Our Ref: EN020032

20 May 2026

Application by Morgan Offshore Wind Limited and Morecambe Offshore Windfarm Limited (“the Applicants”) for an Order granting Development Consent for the proposed Morgan and Morecambe Offshore Wind Farms Transmission Assets (“the Proposed Development”)

REQUEST FOR INFORMATION

Figure 1: Nearshore Offshore Cable Route through Fylde MCZ and KP markers

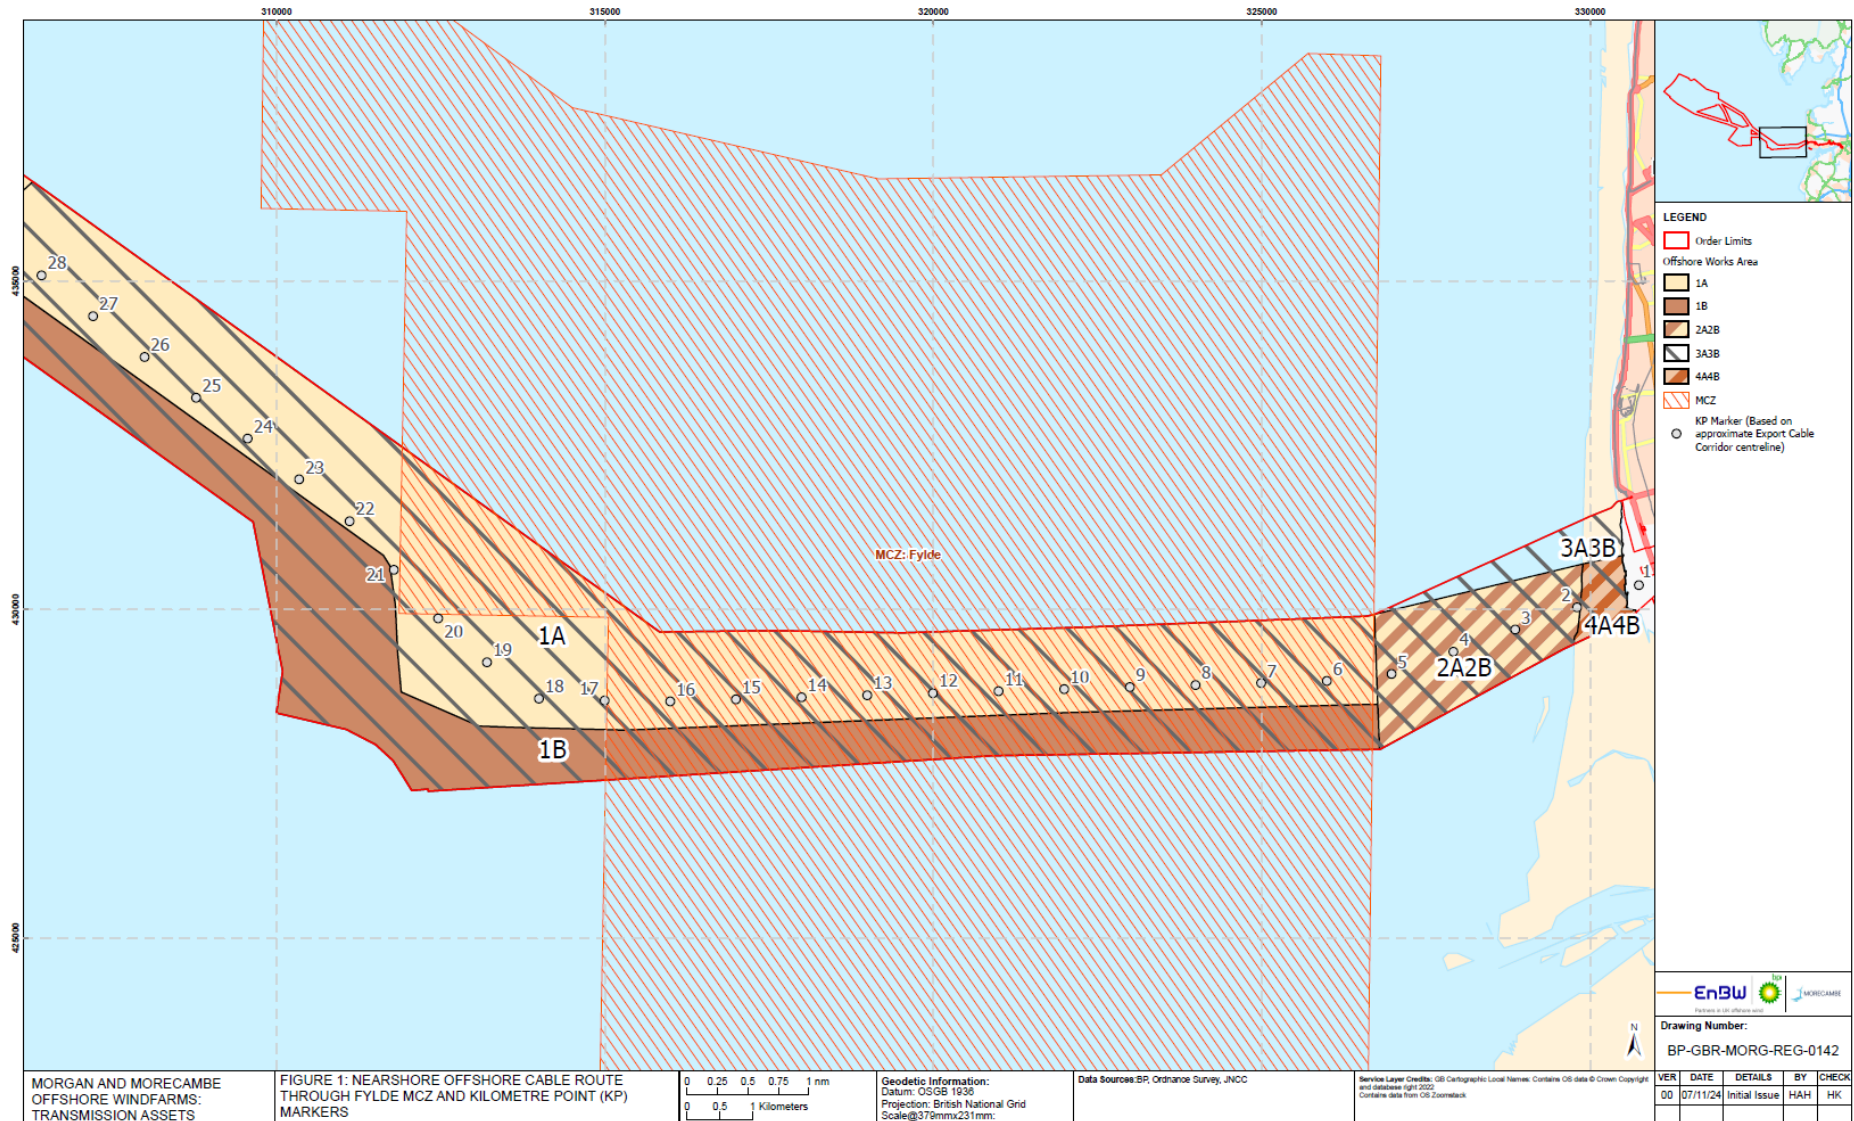
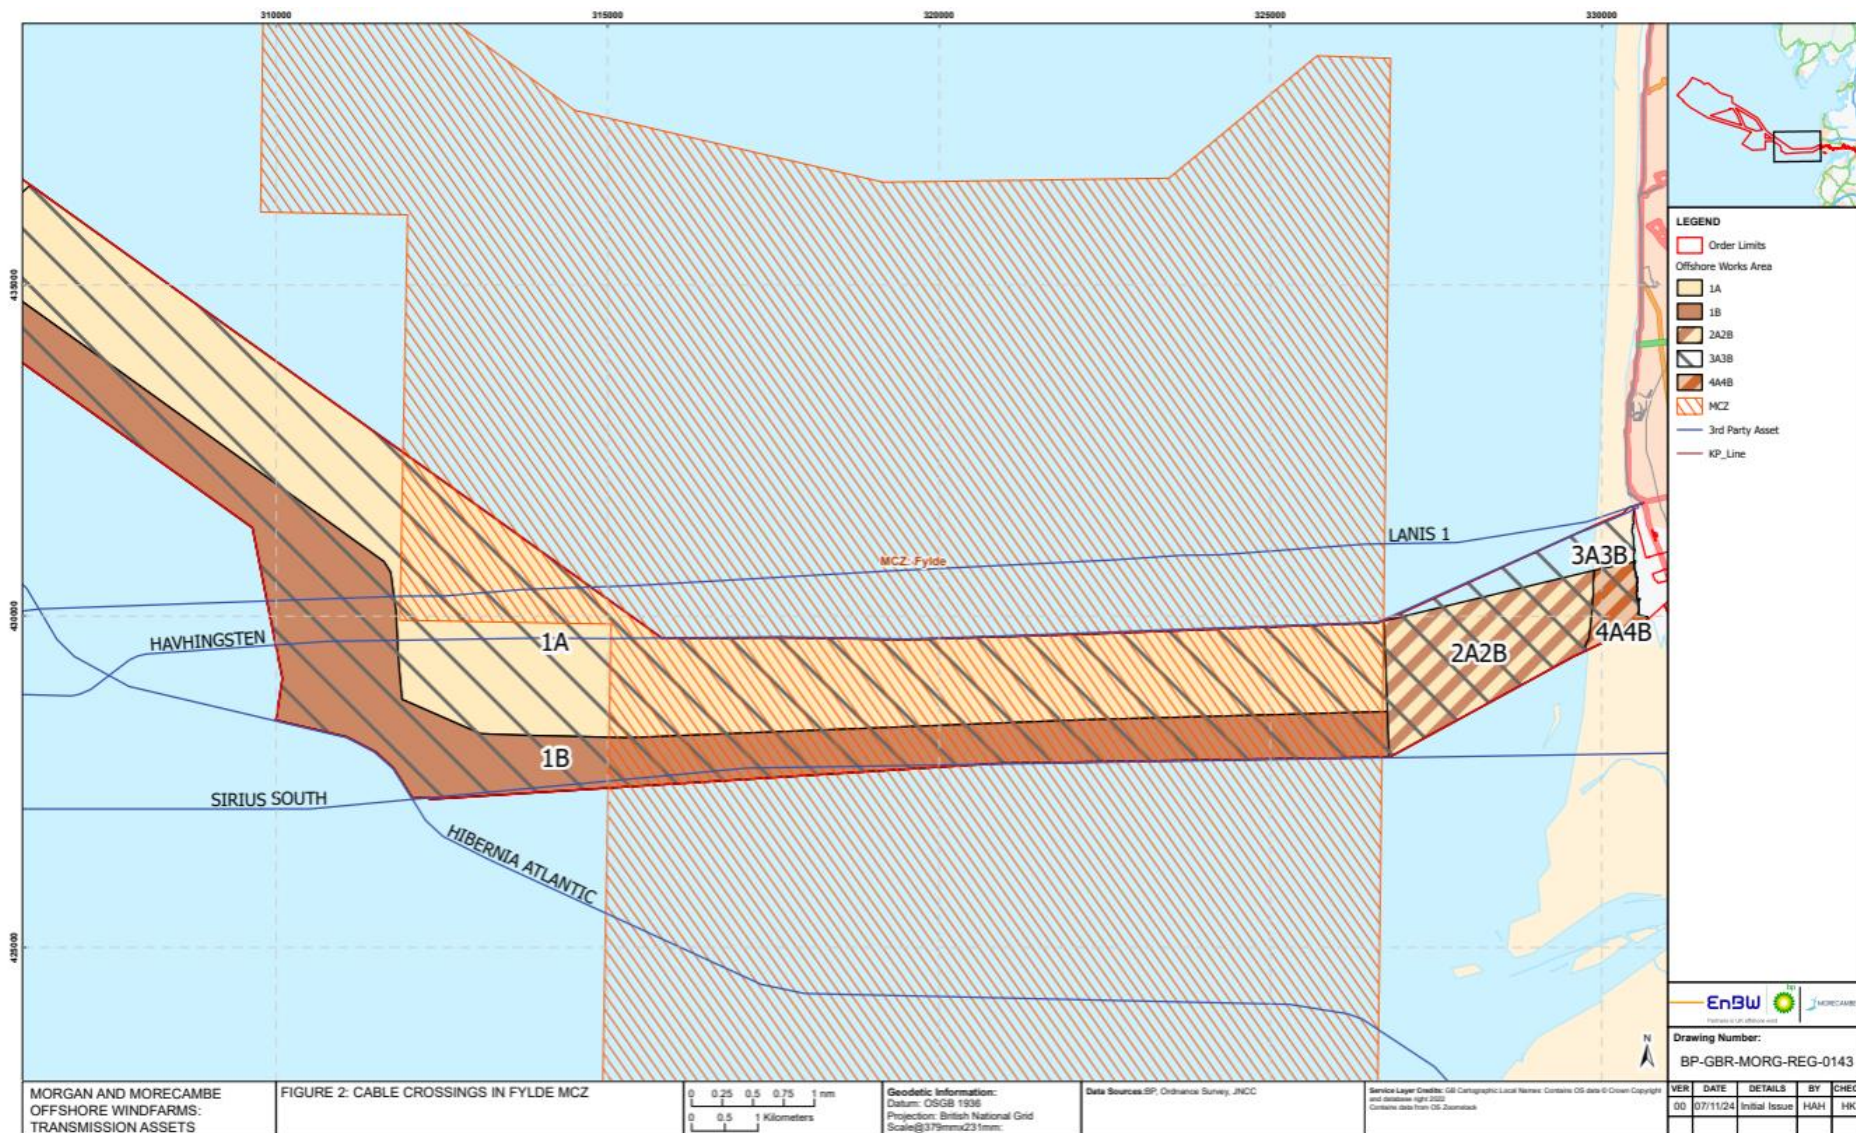
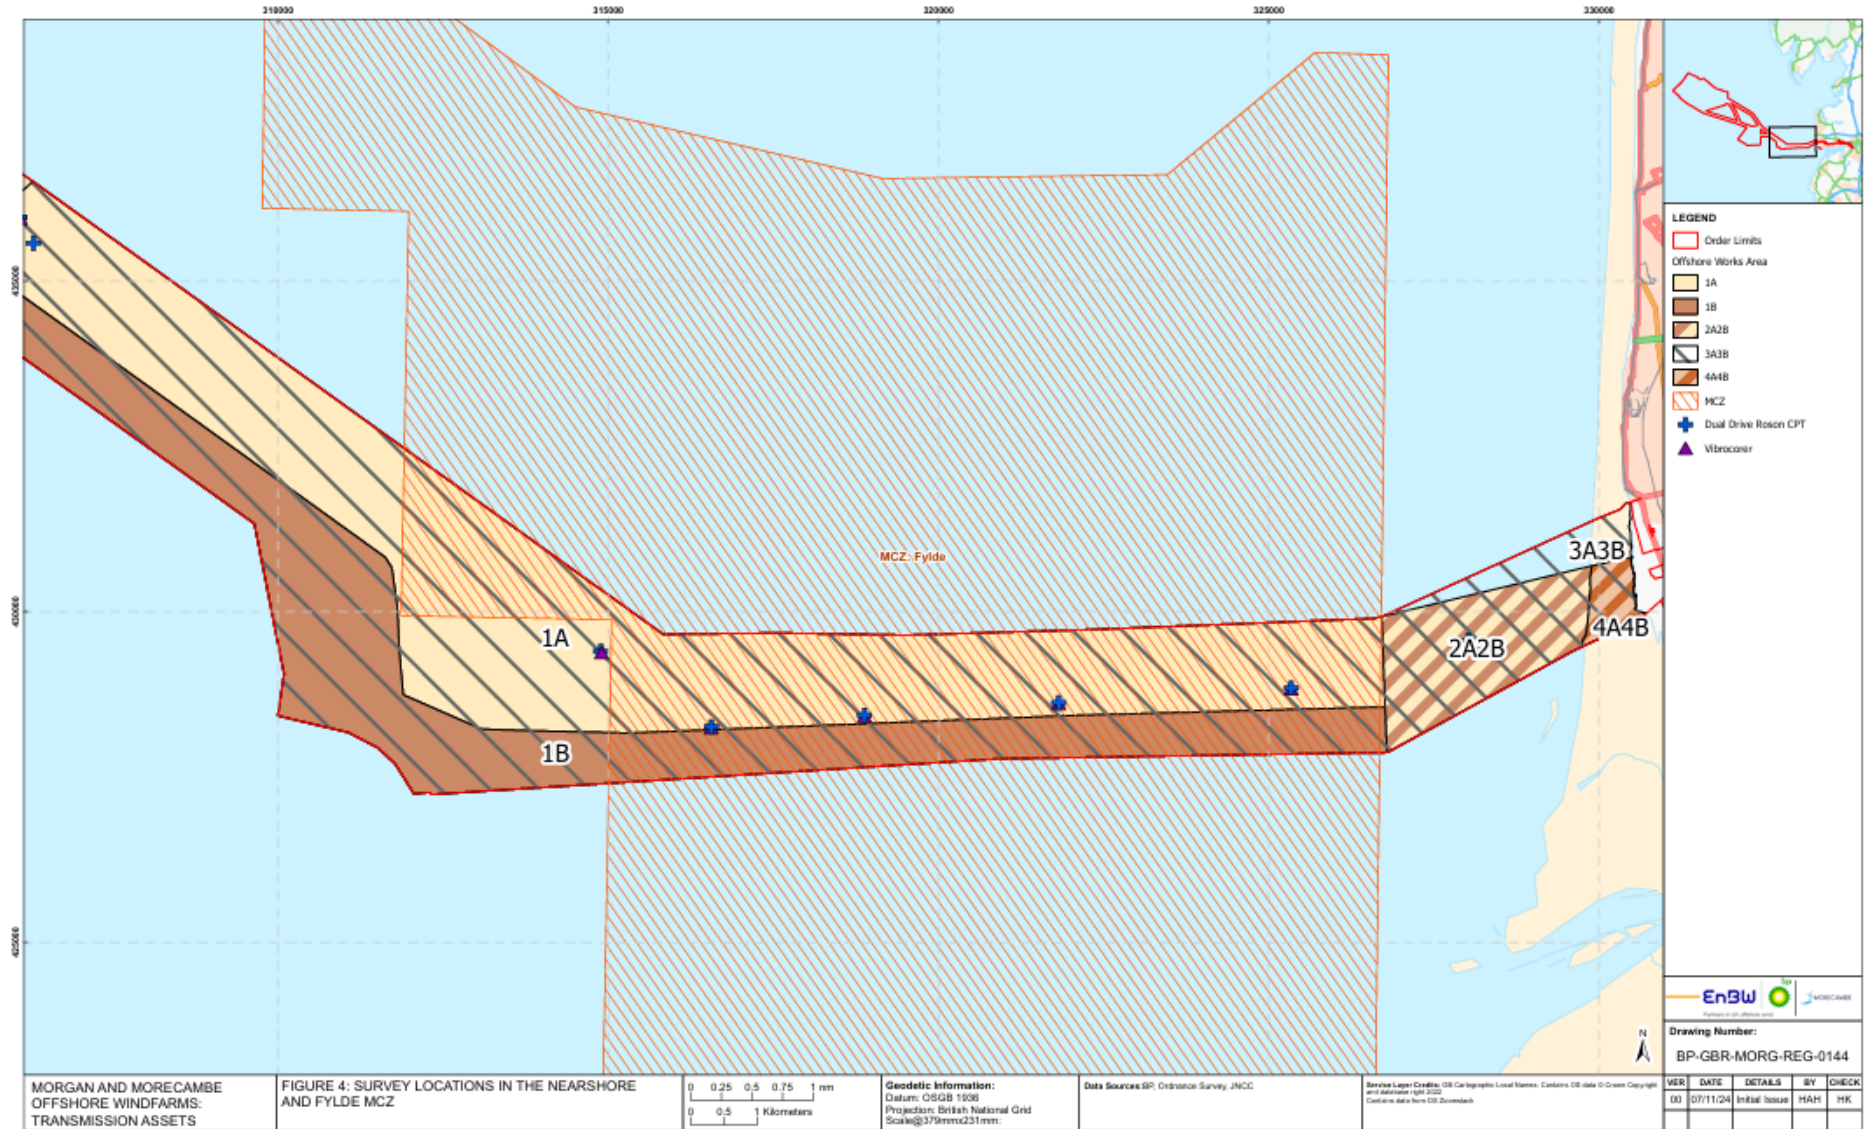
27. To further reduce impacts within the Fylde MCZ the **Applicants** are requested to update the Outline Offshore Cable Specification and Installation Plan to restrict the use of a boulder plough within the MCZ (i.e. to only allow use of a boulder grab) and to require that any relocated boulders will not be deposited to form linear structures. If this is not possible, noting the Applicants position at 3.3.1.2 in [REP7-042], the **Applicants** are requested to explain why a boulder grab would not be appropriate for a high density of boulders.
